CITY OF ALBUQUERQUE

**Re: Orpheum Community Hub,
500 2nd St SW
Request for Certificate of Occupancy
Transportation Development Final Inspection
Engineer's/Architect's Stamp dated 10-08-18 (K14D114)
Certification dated 4-12-19**

Traffic Circulation Layout

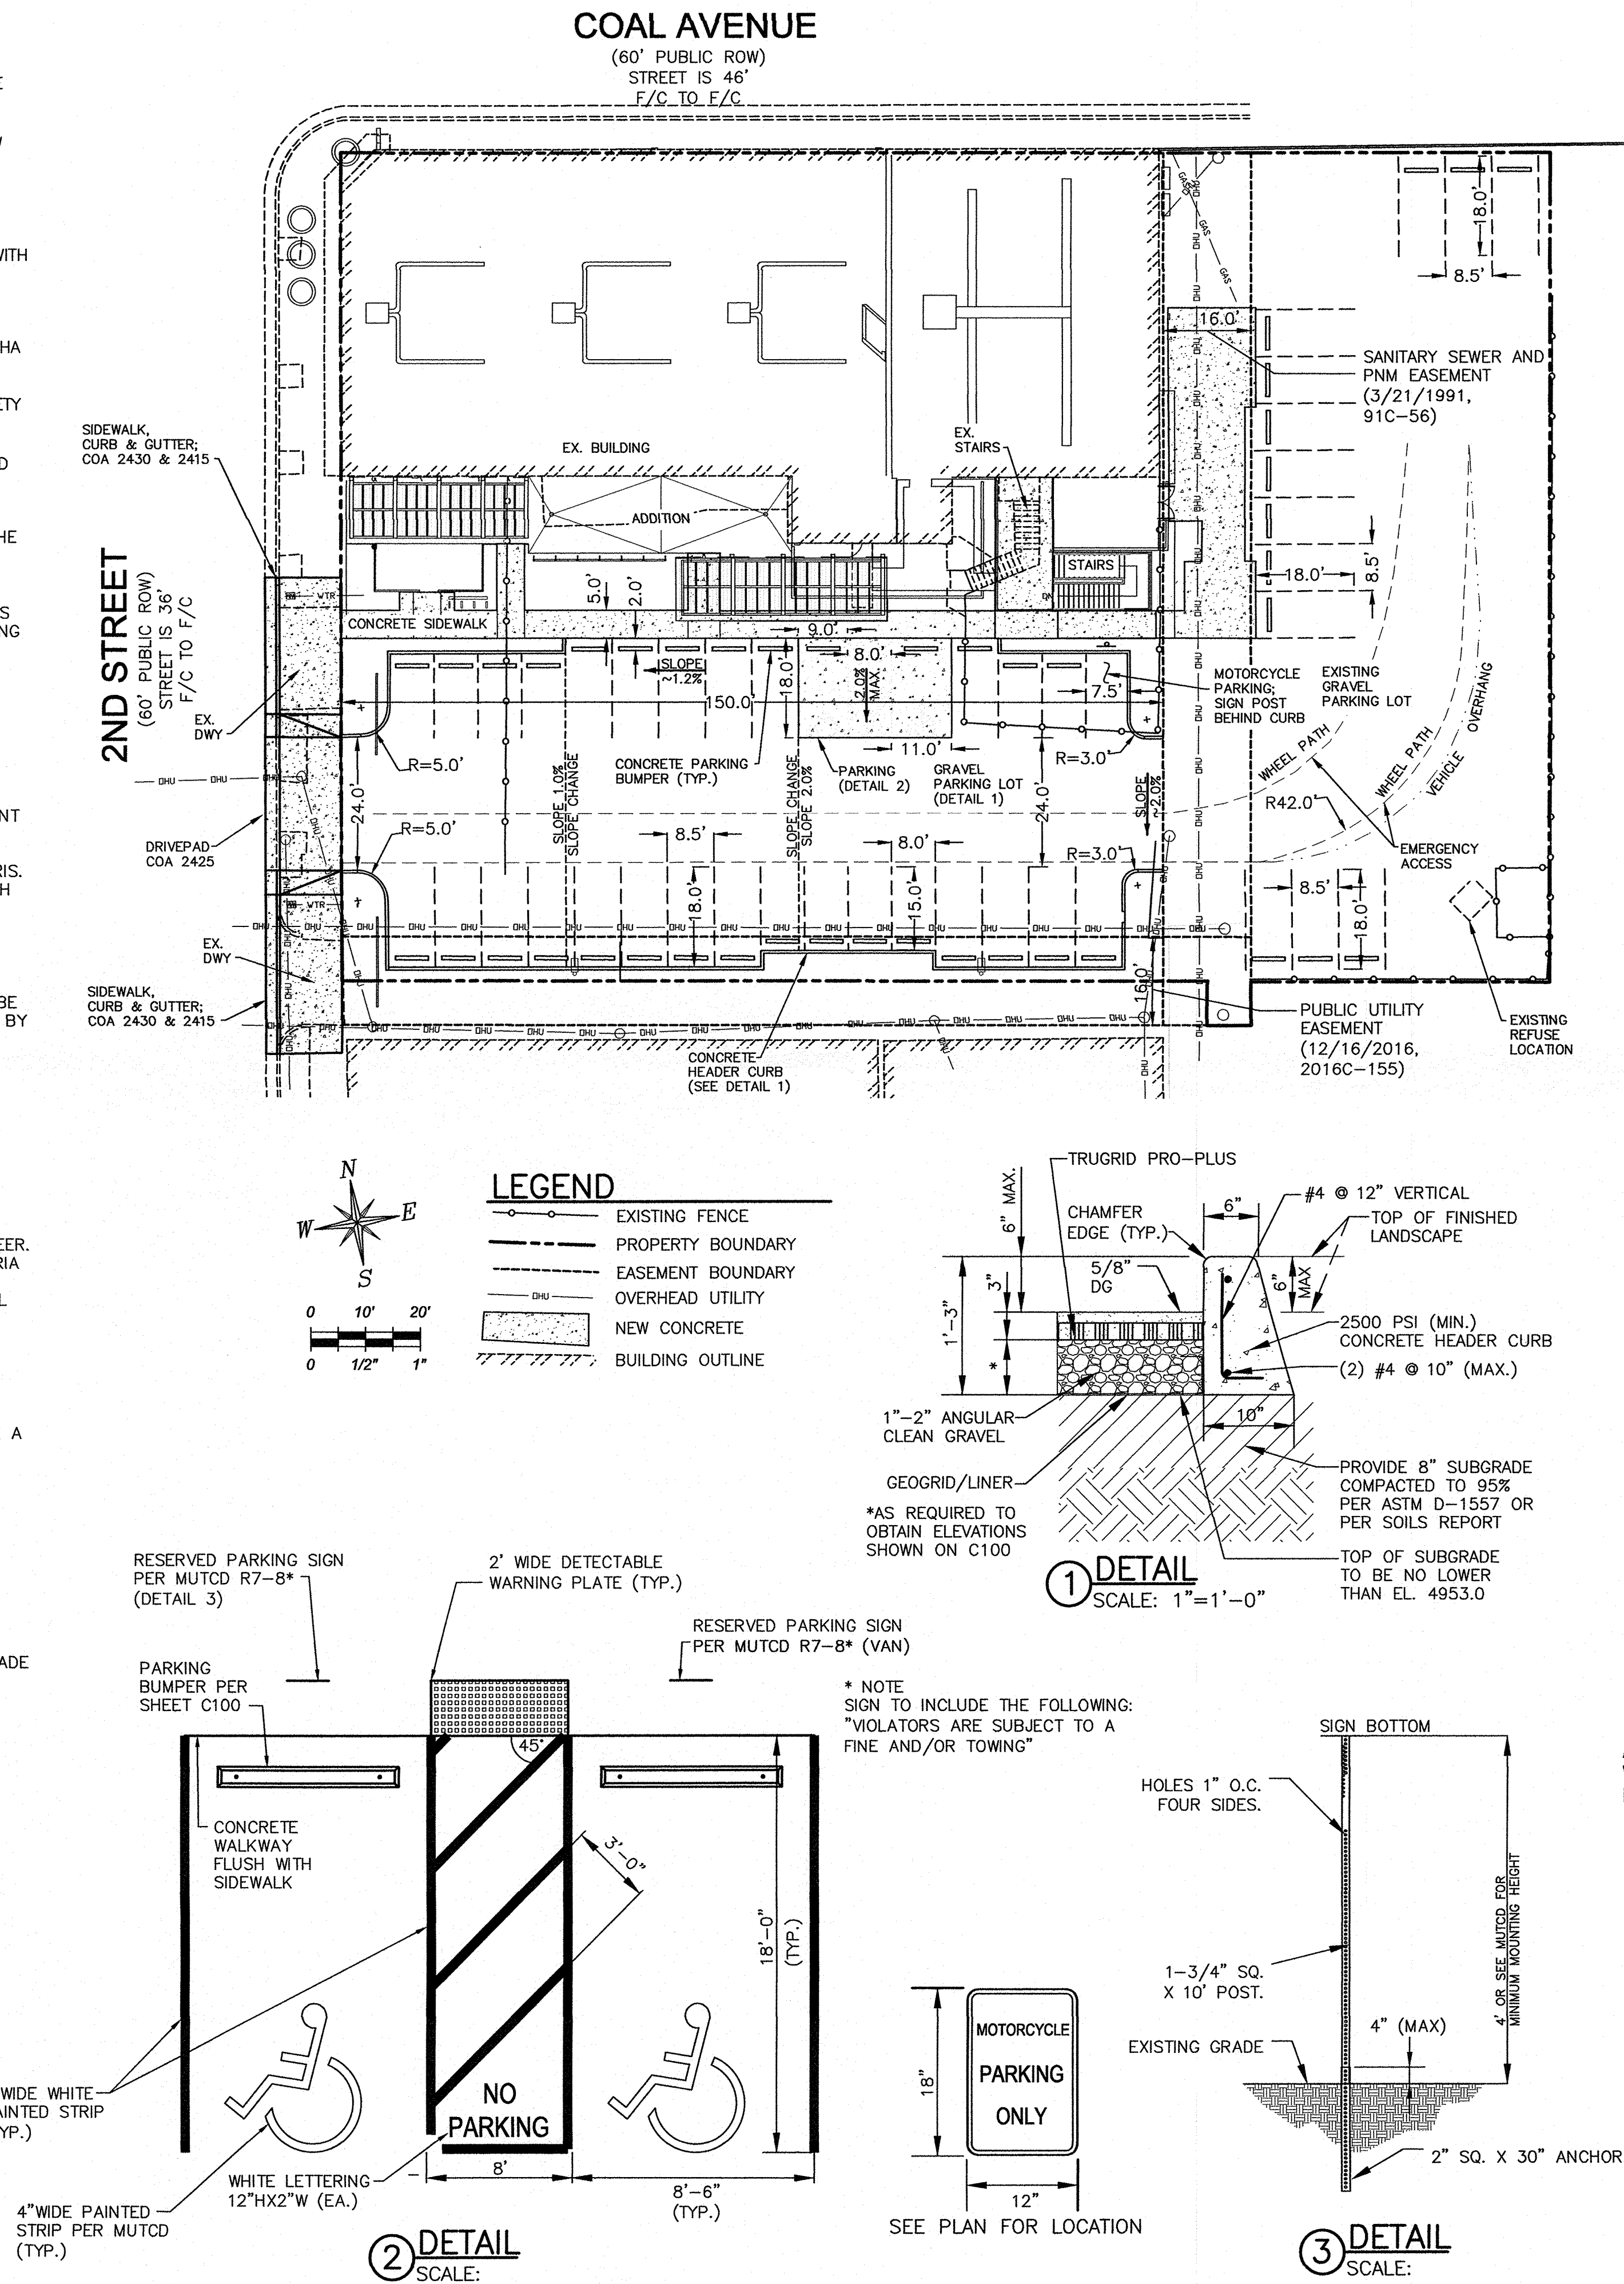
- The east parking lot needs to be Gravel according to TCL.
- The 13 spaces at the east side ^{are} missing.
- Please remove the containers from the motorcycle parking space.
- Remove all construction debris.
